Application by AQUIND Limited for an Order granting Development Consent for the AQUIND Interconnector Project (PINS reference: EN020022)

Submission in relation to Deadline 3 of the Examination Timetable

**Mr. Robin Jefferies Registration Identification Number: 20025045**

**Submitted in relation to Deadline 3 of the Examination Timetable**

Figure 15.49: Indicative Landscape Mitigation Plan Option B(1) (south)

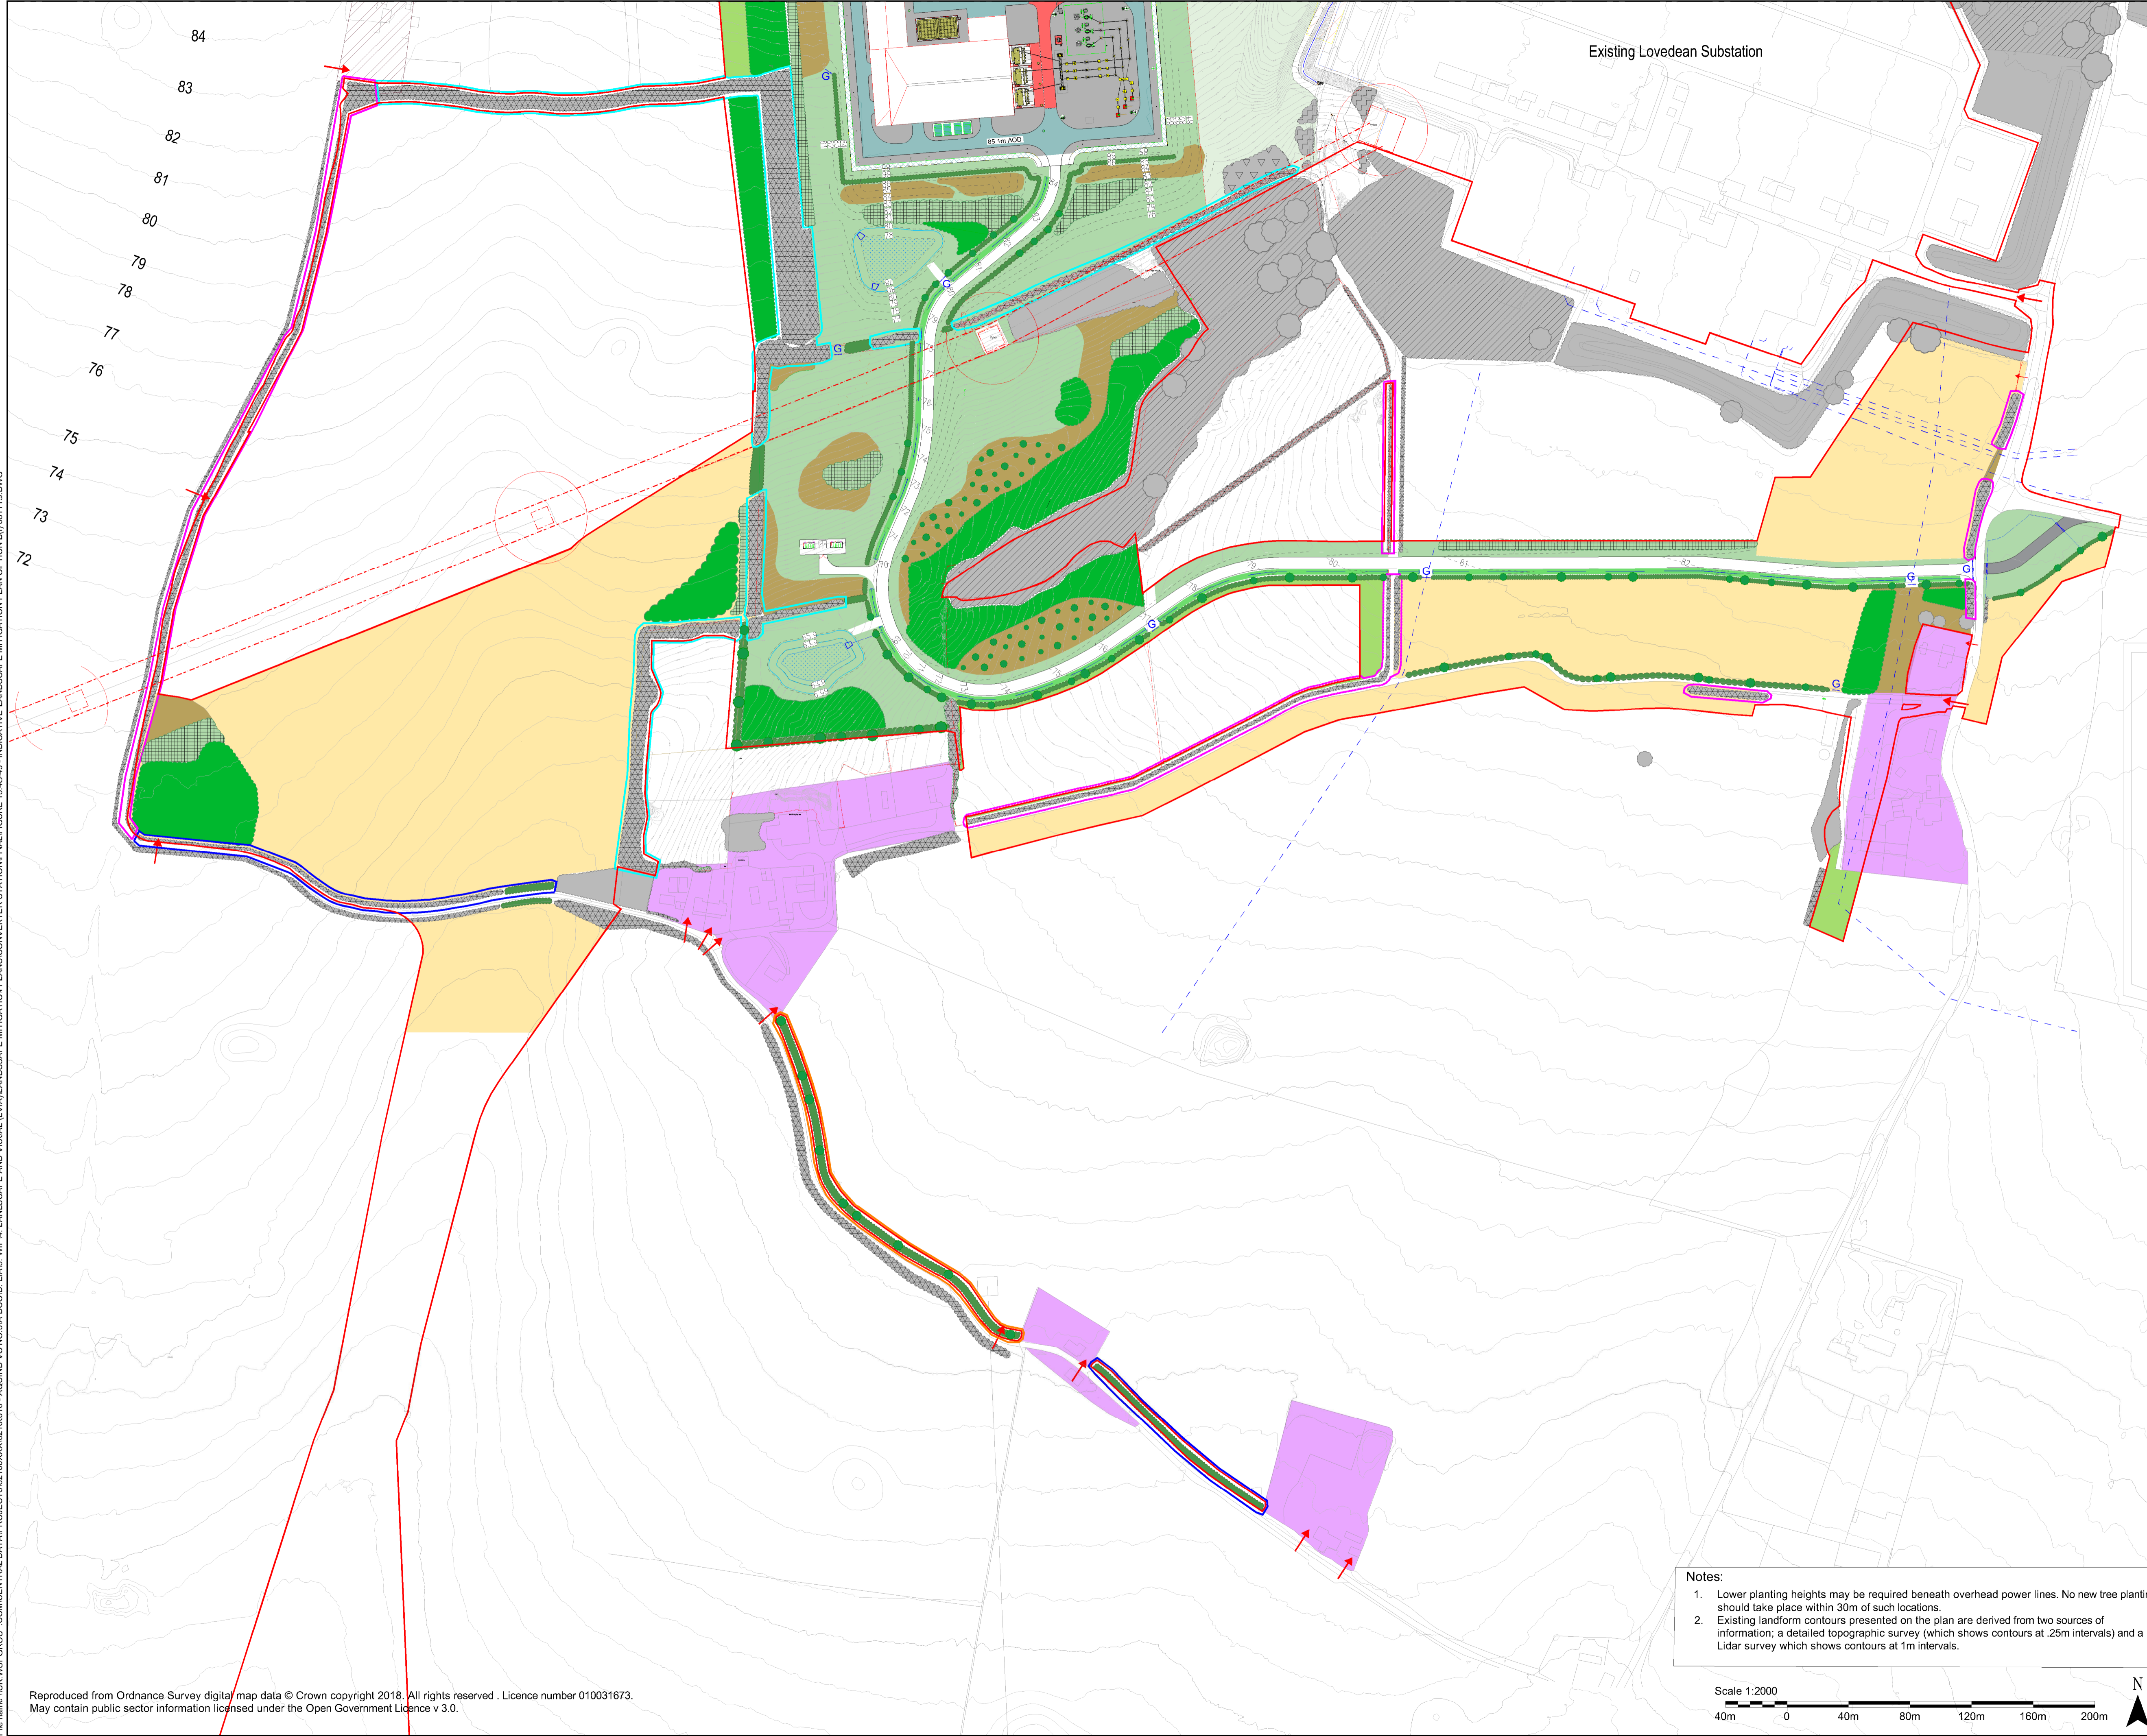
<b>Arguments Contained in Written Representations submitted on behalf of Robin Jefferies (Rep1-239)</b>	<b>Aquind response to Arguments raised in Written Representation Document 7.9.5</b>	<b>Further Comments on behalf of Applicant</b>
<p>Para 5.3.6 The Promoter has failed to explain why the freehold interest to this area of Plot 1-29 needs to be permanently compulsorily acquired for the development or why it is required to facilitate or is incidental to the development.</p> <p>Para 5.3.15 The Promoter has not demonstrated that it has a clear idea of how it intends to use the land which it proposes to acquire contrary to paragraph 9 of the Guidance, nor demonstrated that the compulsory acquisition powers sought are no more than is reasonably required for the development contrary to paragraph 11 of the Guidance .</p>	<p>Plot 1-29, together with Plots 1-20, 1-23 and 1-32 will accommodate the Converter Station, the Telecommunications Buildings, two attenuation ponds, the Access Road and significant areas of landscaping. These are shown on the Indicative Landscape Mitigation Plans for Option B(i) (APP-281) and B(ii) (REP1-137). The landscaping measures proposed in these areas reflect extensive engagement with and feedback received from Statutory Consultees such as Winchester City Council and South Downs National Park Authority regarding concerns over loss of vegetation in this area and the Applicant's proposals will significantly strengthen the landscape features in this area, providing an important visual screening function, as well as</p>	<p>This is very misleading, as neither the Converter Station, Telecommunications Buildings or Attenuation ponds or Access Road will be located on Plot 1-29. It appears the land is solely required for Landscaping.</p> <p>Why can Landscaping rights not be sought?</p>

biodiversity enhancements, to address the feedback received.	
<p>Para 5.3.7 The Promoter has also failed to produce an Indicative Landscape Mitigation Plan in relation to Option B(ii).</p>	<p>These are shown on the Indicative Landscape Mitigation Plans for Option B(i) (APP-281) and B(ii) (REP1-137).</p>	<p>The land area to be compulsory acquired has not altered between Option B (i) &amp; Option B (ii), however the Converter Station has moved some 40m.</p> <p>Much of the land shown as existing pasture, it has not been demonstrated why this land is permanently required for the scheme.</p>
<p>Para 5.3.7 It has therefore not been demonstrated what additional mitigation measures are intended to take place on the remaining part of plot 1-29 to justify its compulsory acquisition of the freehold interest, nor why alternative measures (such as landscaping rights, notwithstanding the submissions below in relation to plots 1-26 and 1-30) are not considered sufficient.</p>	<p>Any third party rights over these areas would be significantly constrained by the potential presence of the Converter Station Site (for Option B(ii)) and the landscaping which is to be located on this land in the event of either option, meaning access and enjoyment of the land will not be possible (for both options) once the landscaping to be provided in connection with the proposals is in situ. It is therefore not considered that the acquisition of landscaping rights only over these areas (noting that landscaping rights are proposed over existing landscaping rather than landscaping which is to be provided in connection with the Proposed Development) would be appropriate, as the land in its current form would no longer be of practical use save for serving its landscaping function in connection with the Proposed Development.</p>	<p>The Applicant has not demonstrated what additional mitigation measures are intended to take place on the remaining part of plot 1-29 to justify its compulsory acquisition of the freehold interest, nor why alternative measures (such as landscaping rights, notwithstanding the submissions below in relation to plots 1-26 and 1-30) are not considered sufficient.</p>
